27 October 2025

Arrangements for Handling Heritage Applications Direction 2021

**SEAS END HALL, HALL LANE, MOULTON SEAS END, SPALDING,
LINCOLNSHIRE, PE12 6LB
Application No. H13-0876-25**

Existing Elevations Of  
Coach House

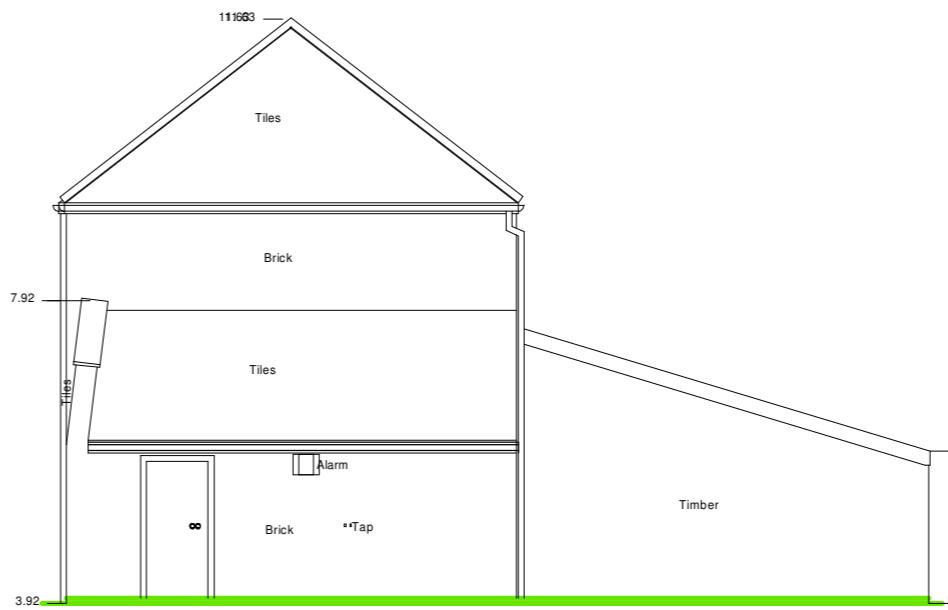
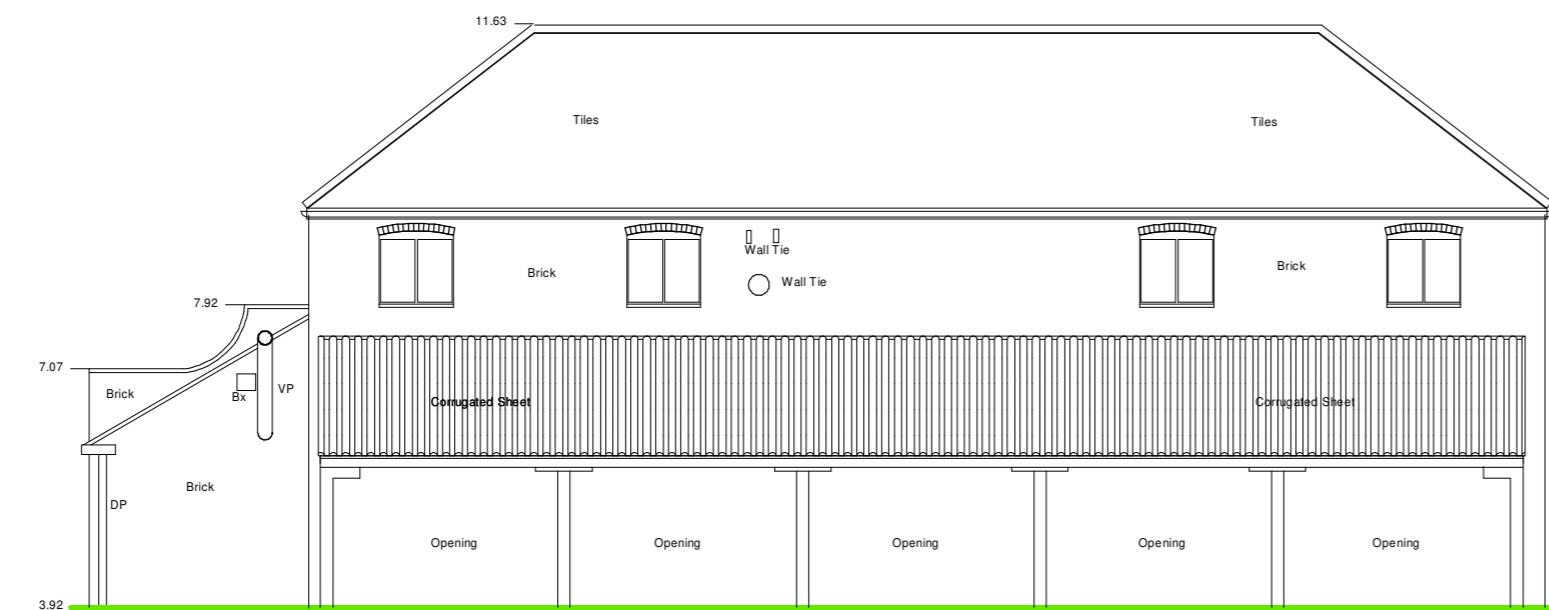
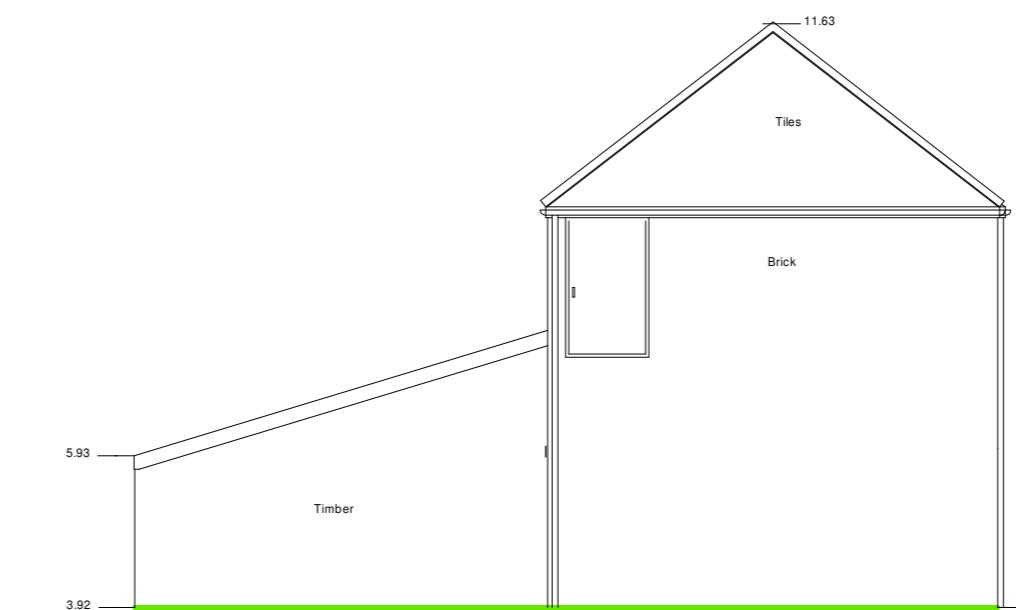
Furthermore, the existing elevations provided appear to show transom lights above the existing Coach House door, however current site photographs indicate otherwise. It is unclear whether the addition of transom lights form part of the proposal. We recommend seeking clarification on this matter.

COACH HOUSE SOUTH ELEVATION

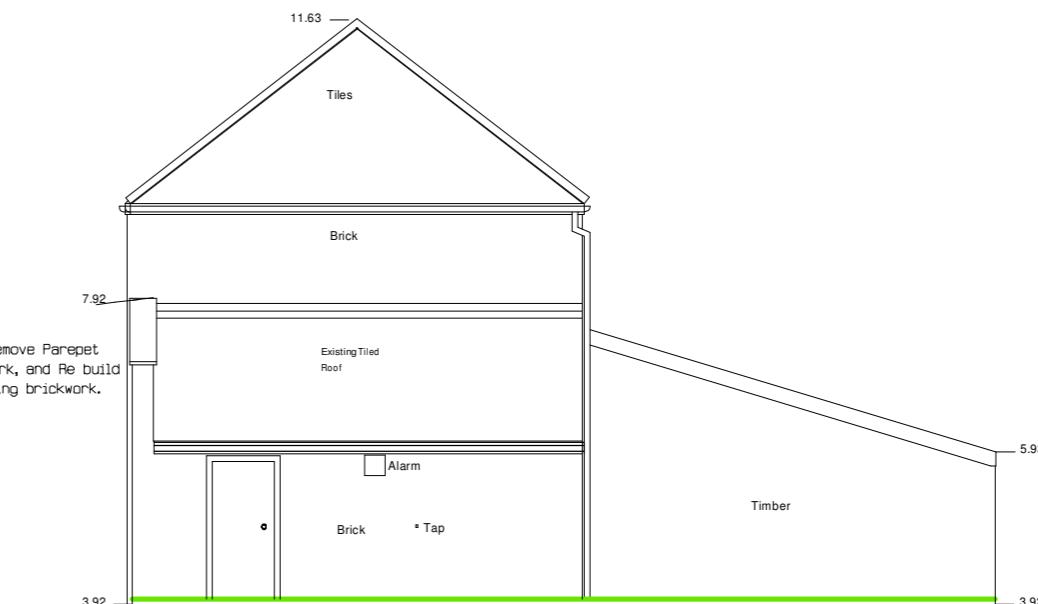
The proposal seeks to install a new window to the façade of the Coach House above the main door, alongside other works.

There is currently insufficient detail regarding this particular part of the proposal which therefore has the potential to cause harm to the significance of the Coach House and that of Seas End Hall through alteration to its setting.

The façade of the Coach House appears to be highly visible in views of the façade of the main house. Changes in this location would need to be sensitive to the historical setting.

Specifications of the proposed window have not been provided. It appears as though the south elevation has undergone change at some point. It is recommended that historical research is undertaken to understand the evolution of the Coach House to then inform proposed changes to the façade. There is also no Statement of Significance which should be provided and used to inform proposed works.
